Planning Application Ref: FP/178/21/T

Location: Junction of Wyke Lane North/Roundle Rd and Roundle Square, o/s 1 & 2 Roundle Avenue and West side of Roundle Square, Felpham, PO22 8LB

Description of works: Various works to various trees

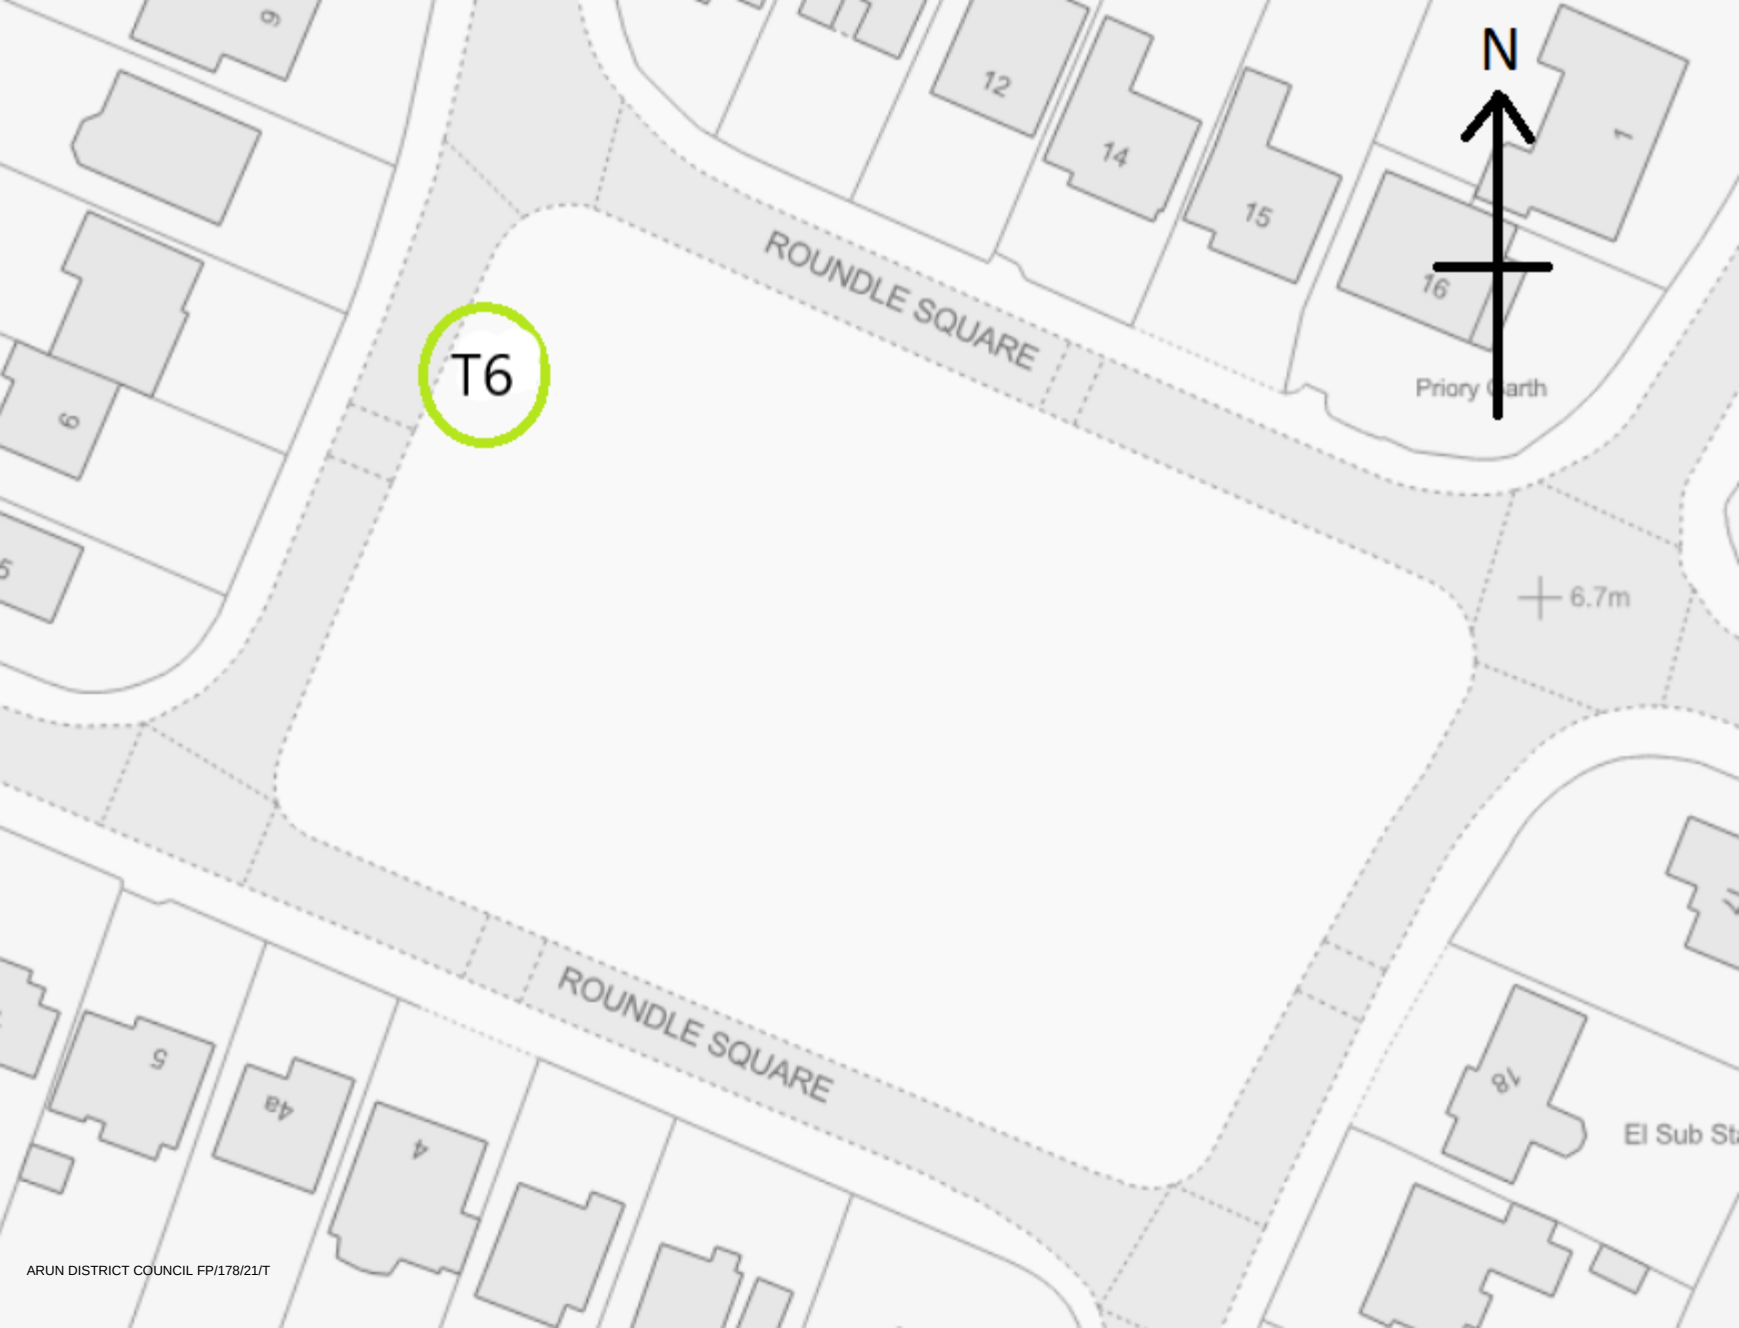
T6 Common ash / *Fraxinus excelsior* Height: 15-20m, Radial spread: 5-10m, Age class: Mature

- The applicant has employed CM Tree Care Ltd. to prepare and submit a tree survey and plans, which recommends a variety of tree work operations.
- There is one Tree Preservation Order which may affect those trees (Bognor No.4), an area Order. Having considered the supporting Schedule and plans, I am satisfied that only items T1, T2 and T6 could be subjects of that Order. Consent from the local planning authority is not required for any work proposed for the other items listed.
- T1 and T2 have effectively been 'topped' in the past and this application seeks to repeat that operation. The extent of regrowth since last undertaken is such that it is now necessary to maintain a degree of structural integrity appropriate for their location.
- T6 is to sustain minor works to address a structural defect, which ought not to incur any loss of amenity.

- I recommend **CONSENT** for this application, subject to the following condition:

Part a) Where whole branches are to be removed and final cuts made close to the trunk or branch union they are to be made as shown in Figure 2 of BS3998:2010

Part b) Where branches are to be shortened back the final cuts are to be made at the correct angle shown in BS3998:2010 and adjacent to a live bud or lateral.

Part c) The removal of crown material which has developed since the last operation must be done sympathetically and with respect to established 'knuckles' so as not to extend beyond the point of origin.

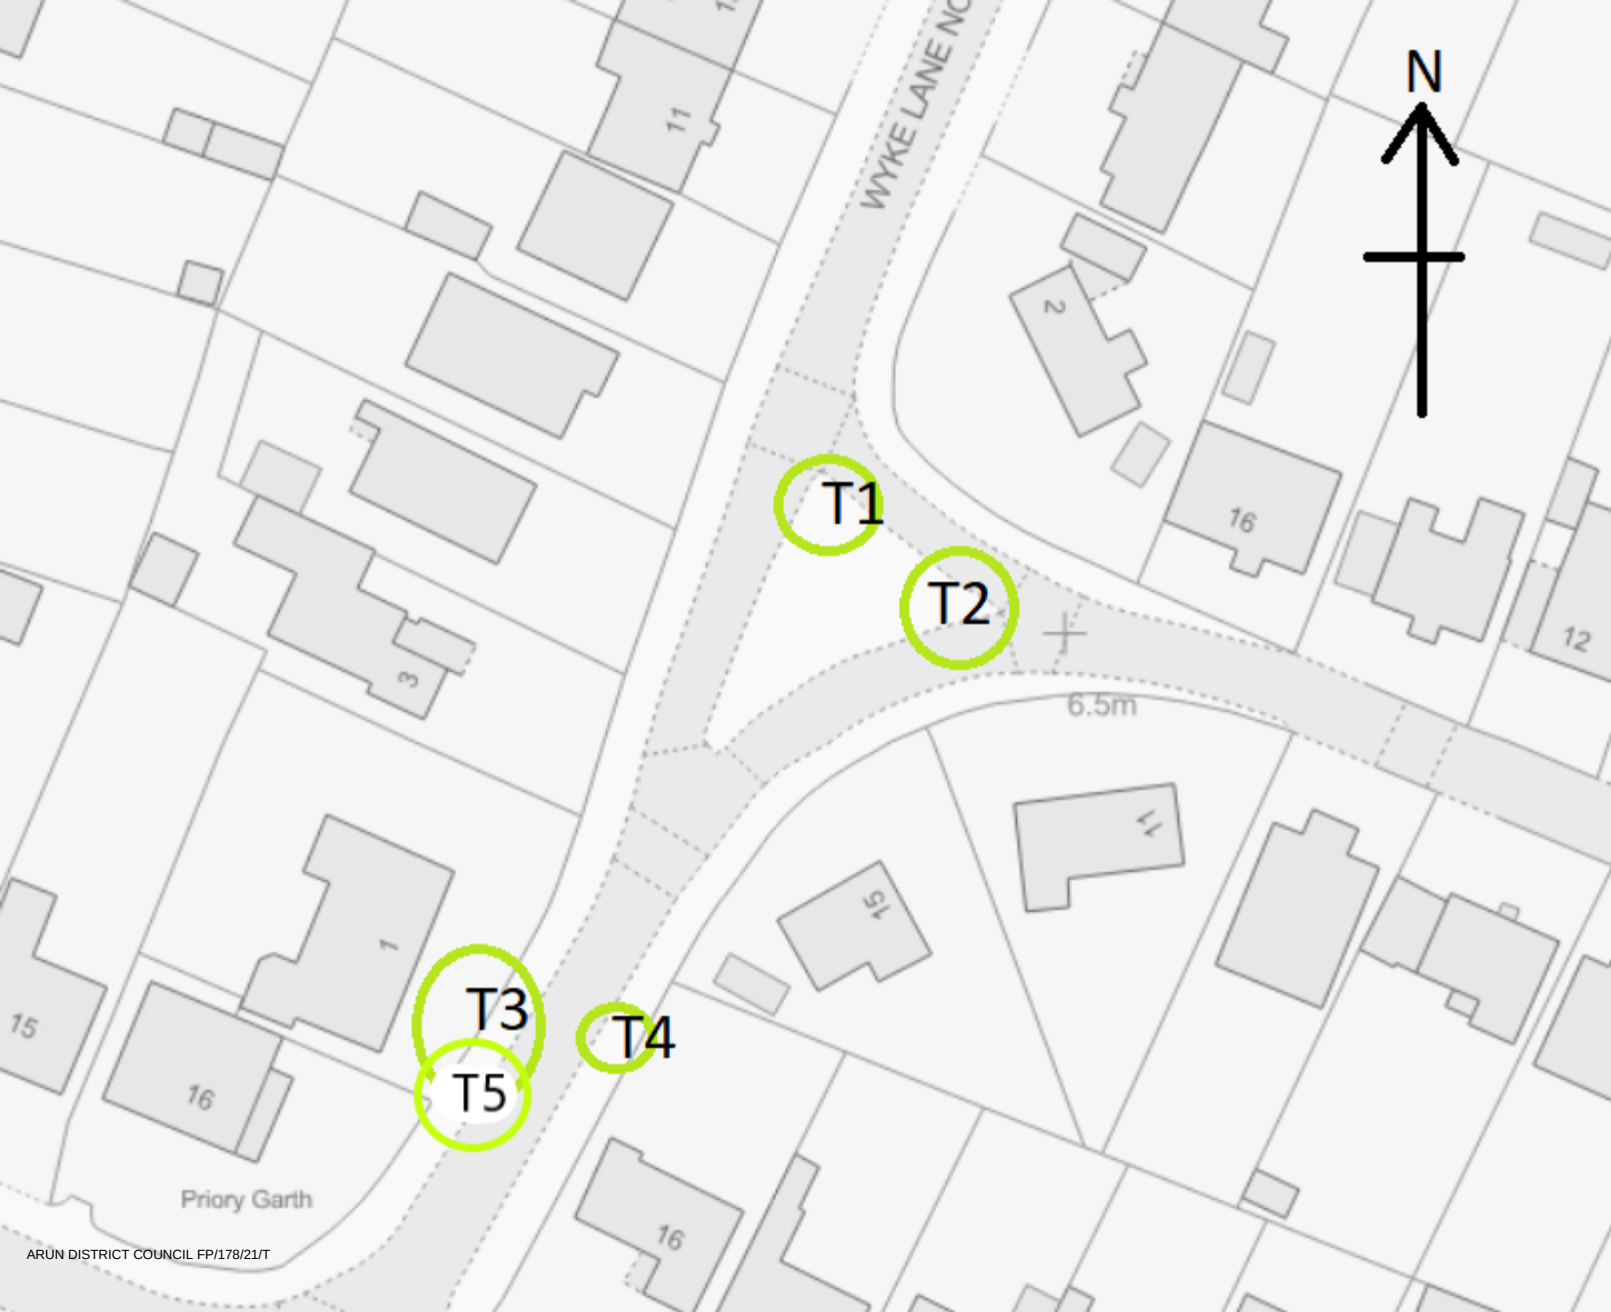
T1, T2 Lombardy poplar / *Populus nigra Italica* Height: 15-20m, Radial spread: 0-5m, Age class: Mature

- The work proposed has been justified on arboricultural grounds.
- The proposal to reduce overall height and spread (T1, T2) with a view to restricting their growth is justified and consistent with previous works approved by the Local Planning Authority. While a temporary loss of aesthetic value is inevitable, satisfactory canopy renewal and recovery should occur if the work is undertaken to a high standard and at an appropriate time of year.

- The long-term vitality of trees (**T1, T2**) is best respected when significant pruning work such as proposed, is undertaken during the mid-winter (late-December to early-February) period. The work should only be undertaken during this period.
